Application no: 21/02376/DISC

Location: E P Barrus Ltd, Launton Road, Bicester, OX26 4UR

Local Lead Flood Authority

Objection to Discharge of Condition 6

<table><tr><td>Drawn By:</td><td>RS</td><td>Client:</td><td>Markbank Construction Ltd</td></tr><tr><td>Scale @ A0:</td><td>1:200</td><td>Title:</td><td>Proposed Drainage Layout</td></tr></table>

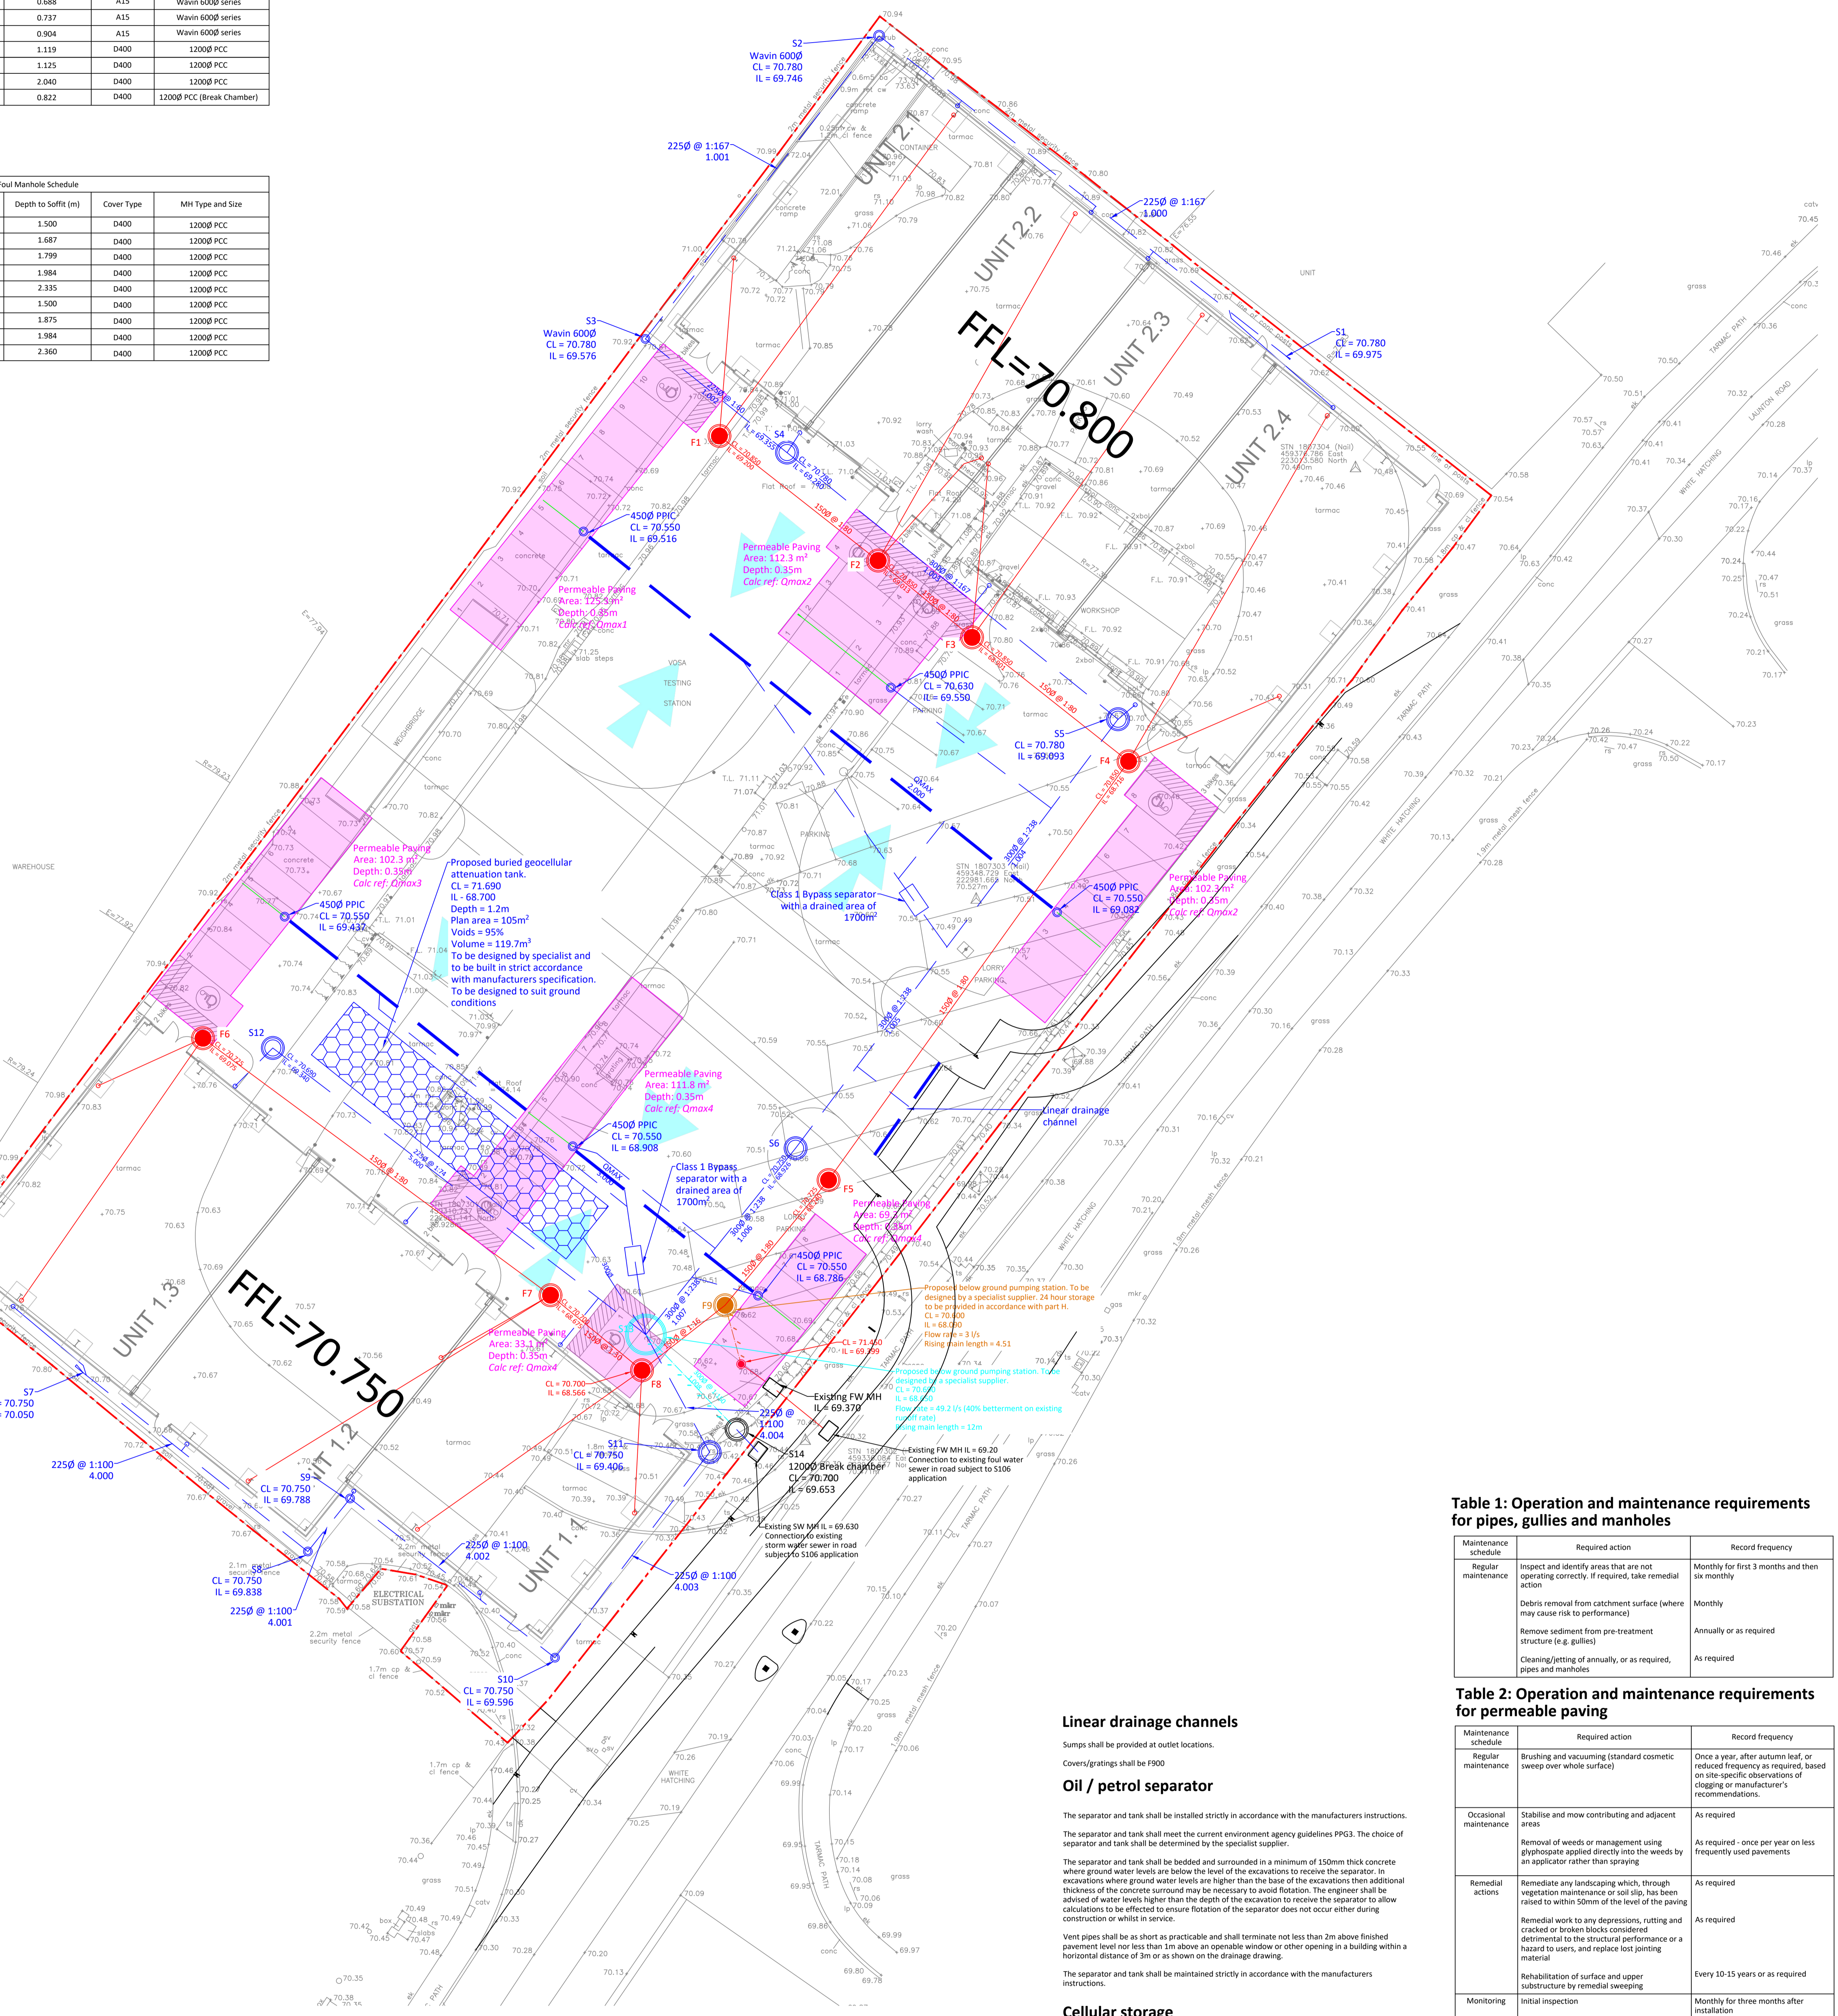
Insufficient information was provided in the Flood Exceedance Layout and surface water drainage layouts;

Drainage calculation for the 1 in 1 year, 1 in 30 year and 1 in 100 year + 40% climate change were not provided to confirm the required sizes for SuDS.

No details provided of the future maintenance and management of the site SuDS features.
